**Case Officer:** Catherine Harker      **Recommendation:** Approve

**Applicant:** Sir Stephen Gomersall

**Proposal:** Relocation of staircase, minor internal alterations associated with staircase and alterations to a single window and external door

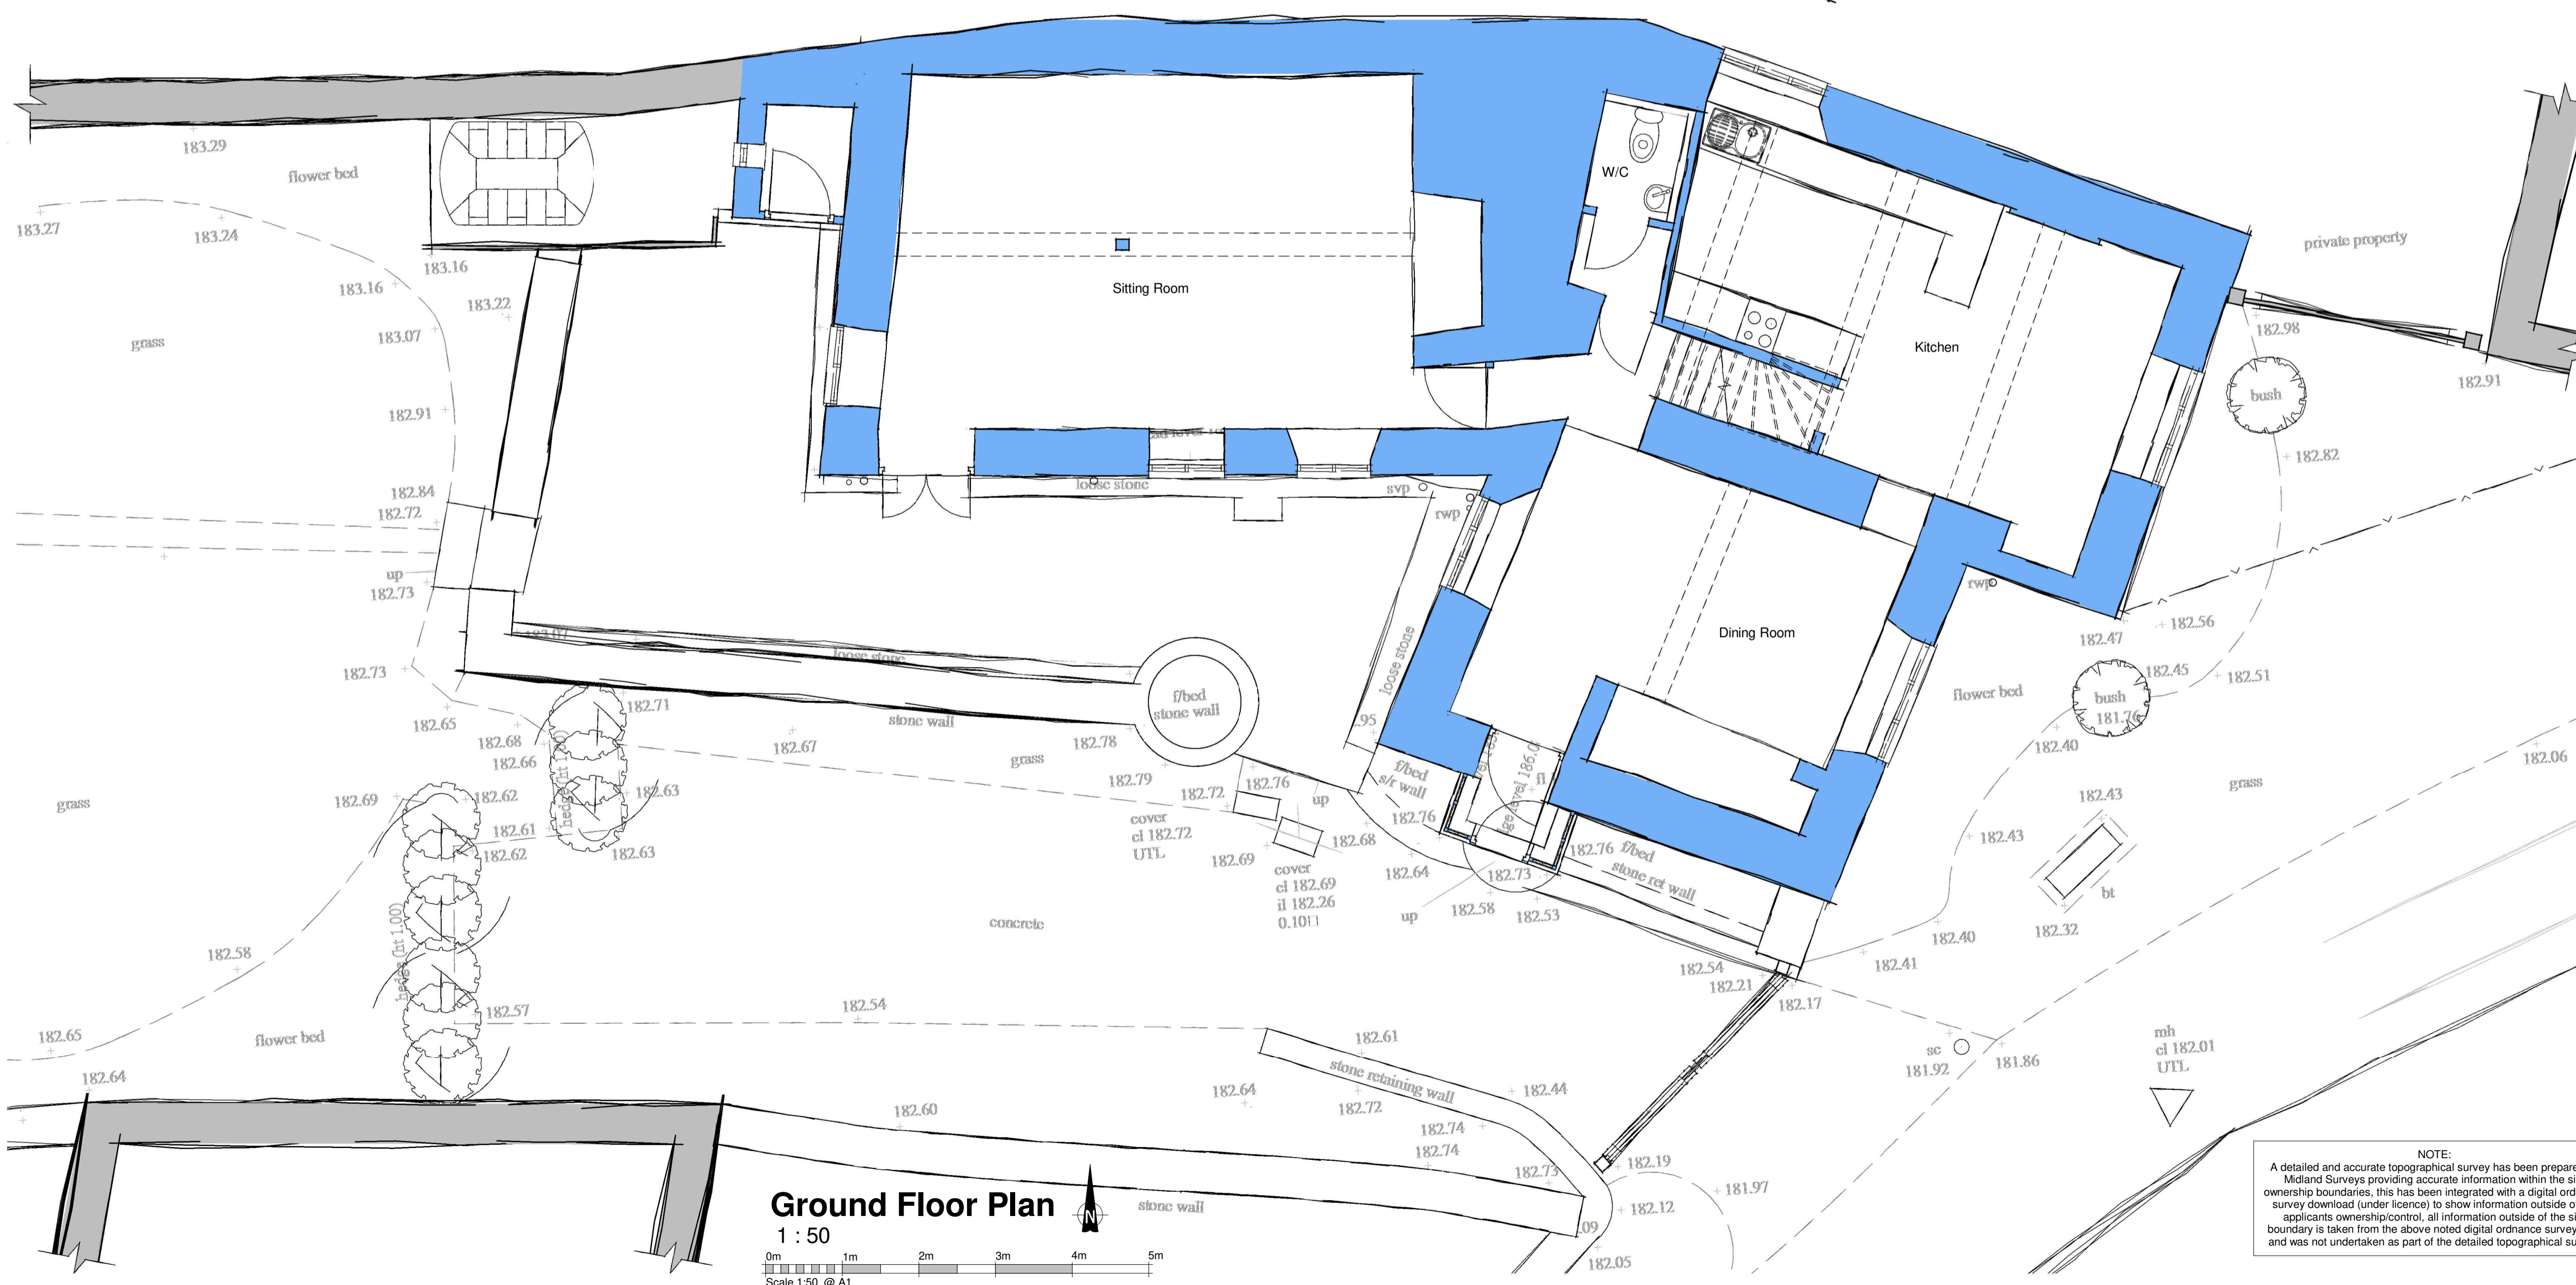
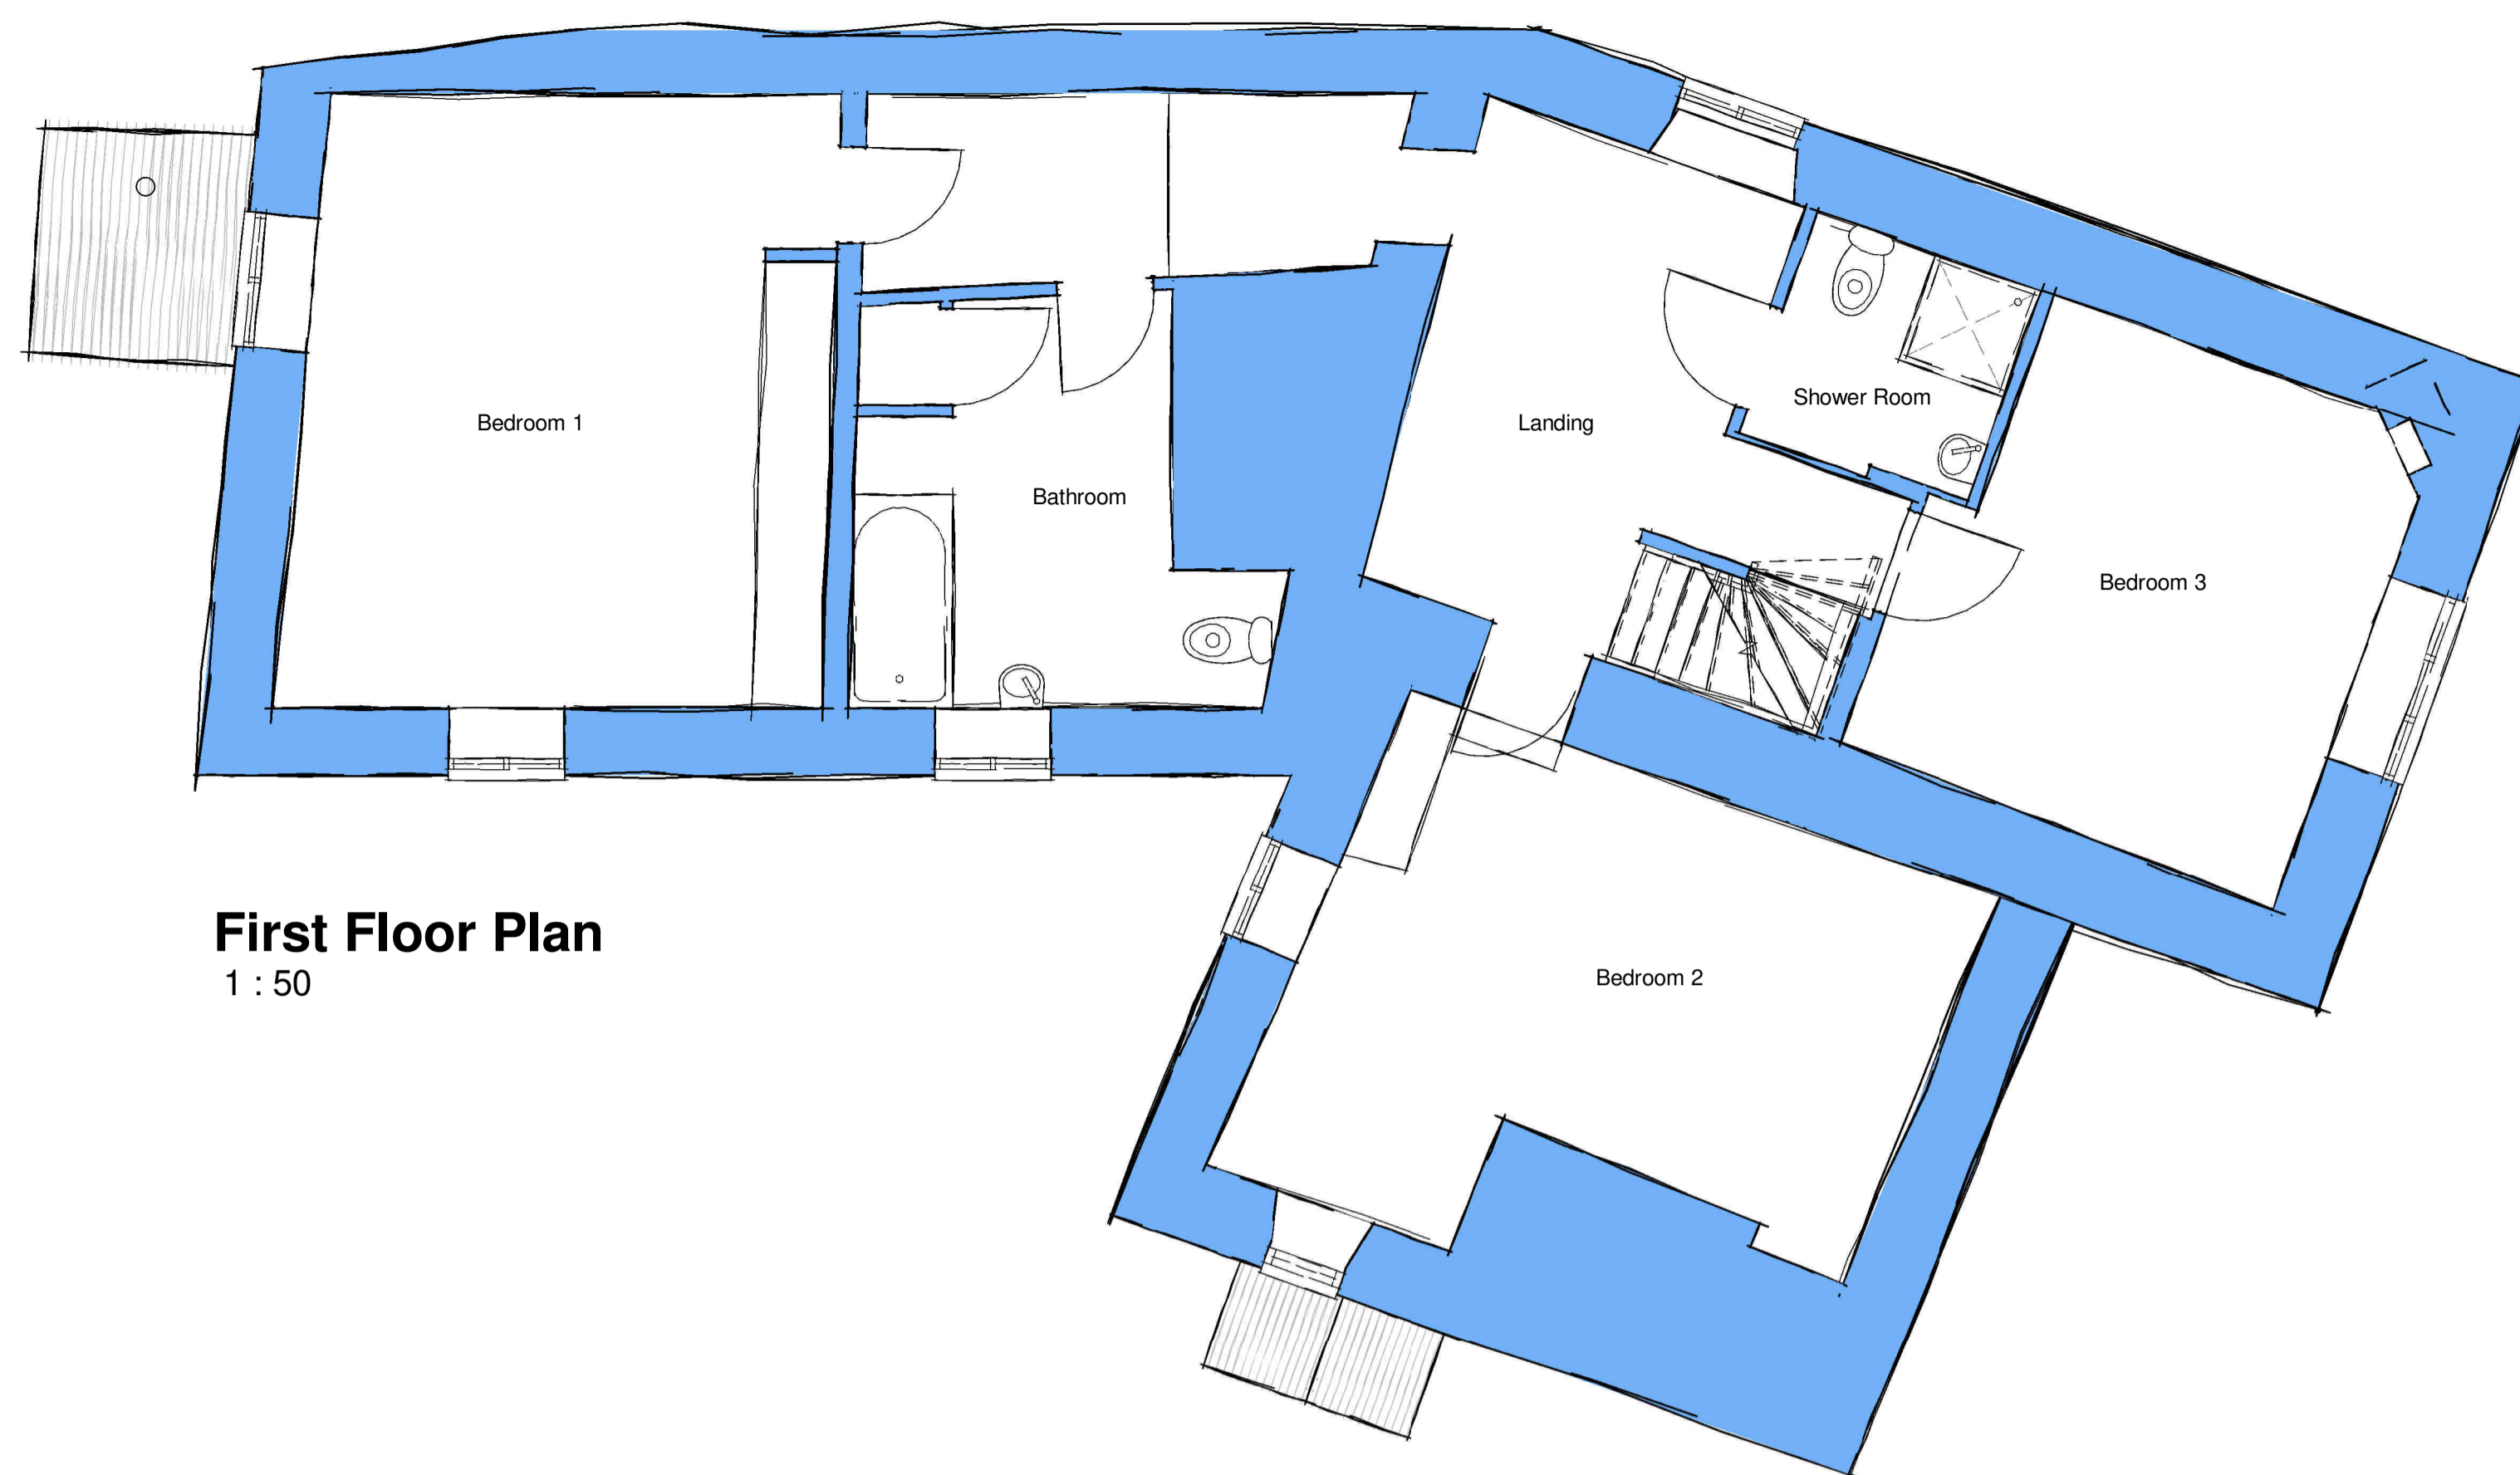
Further investigative work has now been undertaken into potential alternative locations of the stair with the Heritage Report stating 'There is a general agreement that the vast majority of the staircase from the ground to first floor, including the enclosure is all new work. Three treads show evidence of being older, however, they have newly sawn edges and are fixed into a completely new string. From this it cannot be confirmed that these treads represent a surviving element of an earlier staircase. Even if they were, the historic value that they now hold is negligible. Given they are also in softwood it is probable that the timber derives from the 19th or early 20th century'. 'Careful lifting of the floor boards at the top of the first flight of stairs shows that The floor joists, which are deeper than wider, and are not morticed and housed as would be expected, but rather crudely notched and laid over the structural transverse beams. This means that the joists were laid after the building had been constructed. The dimensions and spacing of the joists suggest they are not 17th century but later. The surface finish on the joists vary across the floor, again suggesting some level of reuse. The floorboards, which are wide and early, do not line through, with the undersides of those exposed covered in limewash. There is an area of modern chipboard, in the NW and NE corners of the first floor, almost certainly dating from the 1980s. This building sequence suggests that this area may have been the location for an earlier staircase, and would be a more logical location'.

This evidence alongside the revised understanding of the phasing of the building, the fact that the stair location is a non-conventional location for vernacular buildings

in the region and that only 3 stair treads remain provides sufficient doubt to allow the stair to be removed (subject to recording of its current location).

3. Prior to the commencement of works to the stairs, method statements for the removal of the existing stairs, removal of the historic nib and installation of the new stairs, shall be submitted to and approved in writing by the Local Planning Authority. The works thereafter shall be undertaken in accordance with the approved method statements.

Proposed Sheet 2

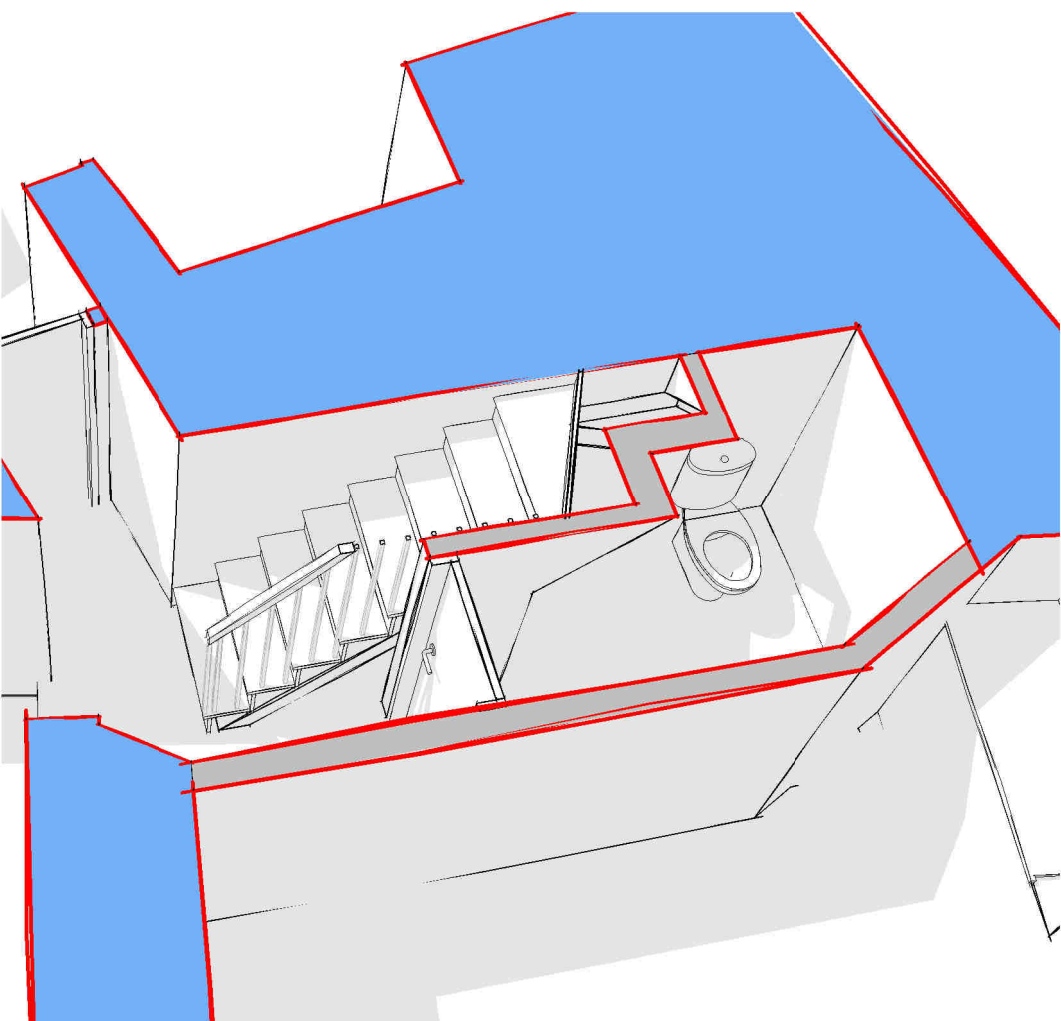
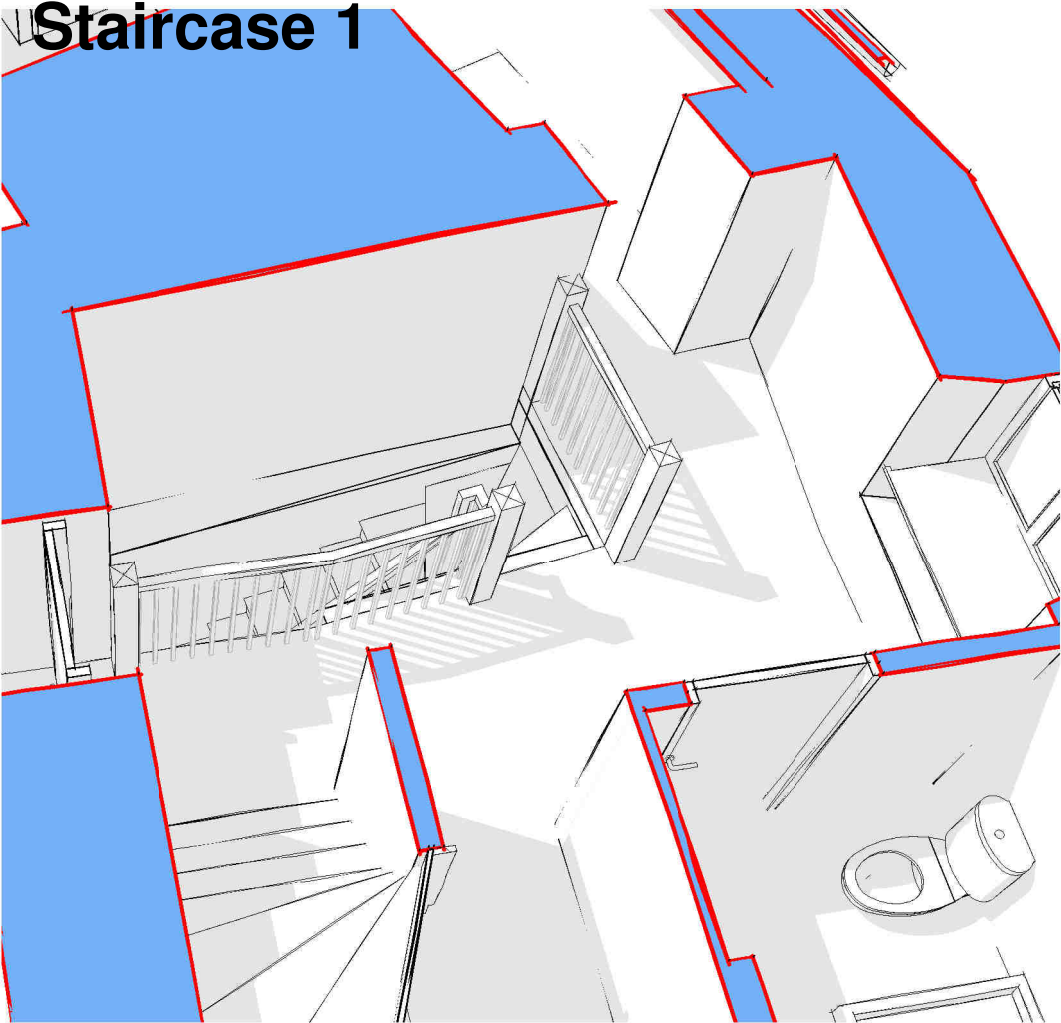
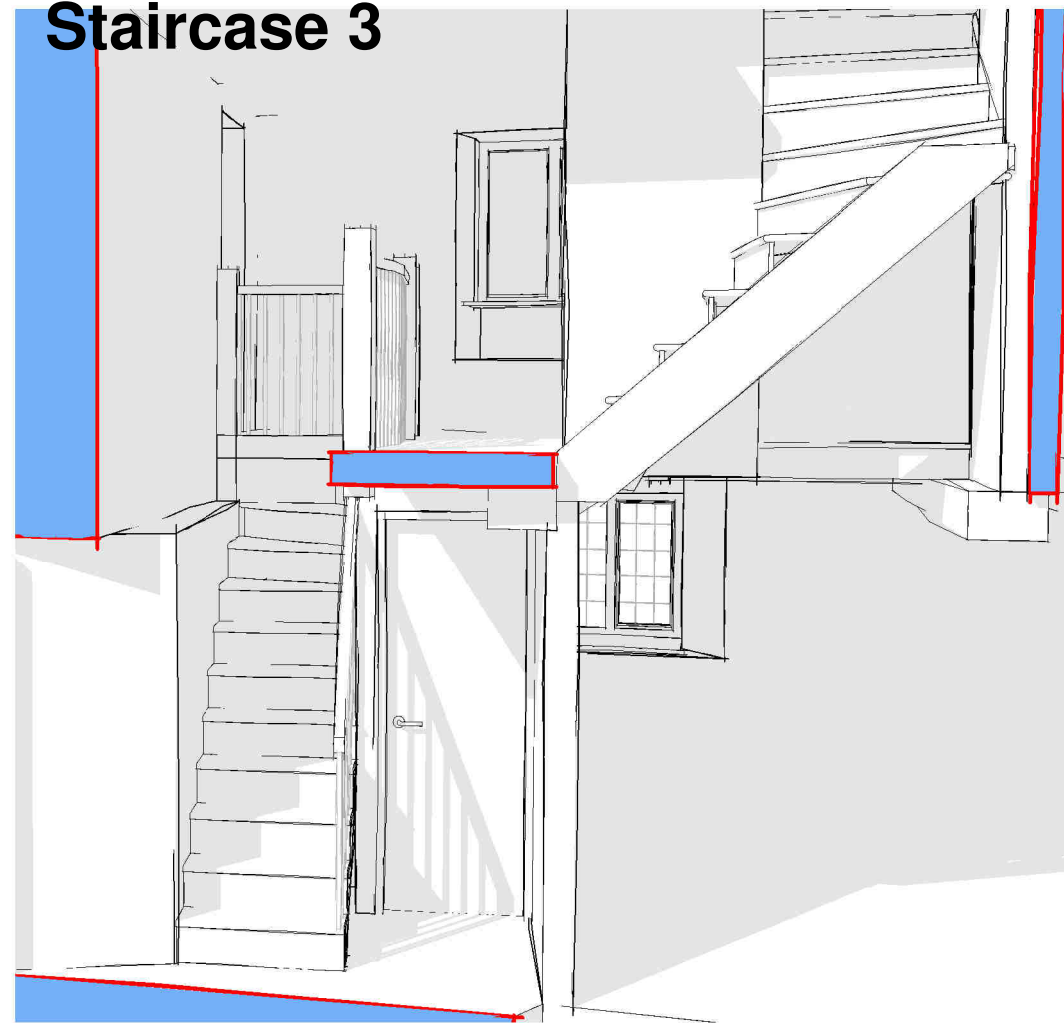
There are no objections to the principle of the relocation of the window and French doors on the south and west elevations. It is understood from the Design and Access Statement that the existing doors will be relocated in the gable end.

4. Any remedial stonework necessary for the repair or making good of the walls to the original building shall be carried out by re-using the existing stonework wherever possible, and where new stone is required, shall be carried out in natural stone of the same type, colour, size, shape, texture and appearance as the stone to the existing building and shall be laid, coursed, dressed to match the existing outbuilding walls. Any pointing shall be done using a lime based mortar to match the existing building and to protect the natural stonework.
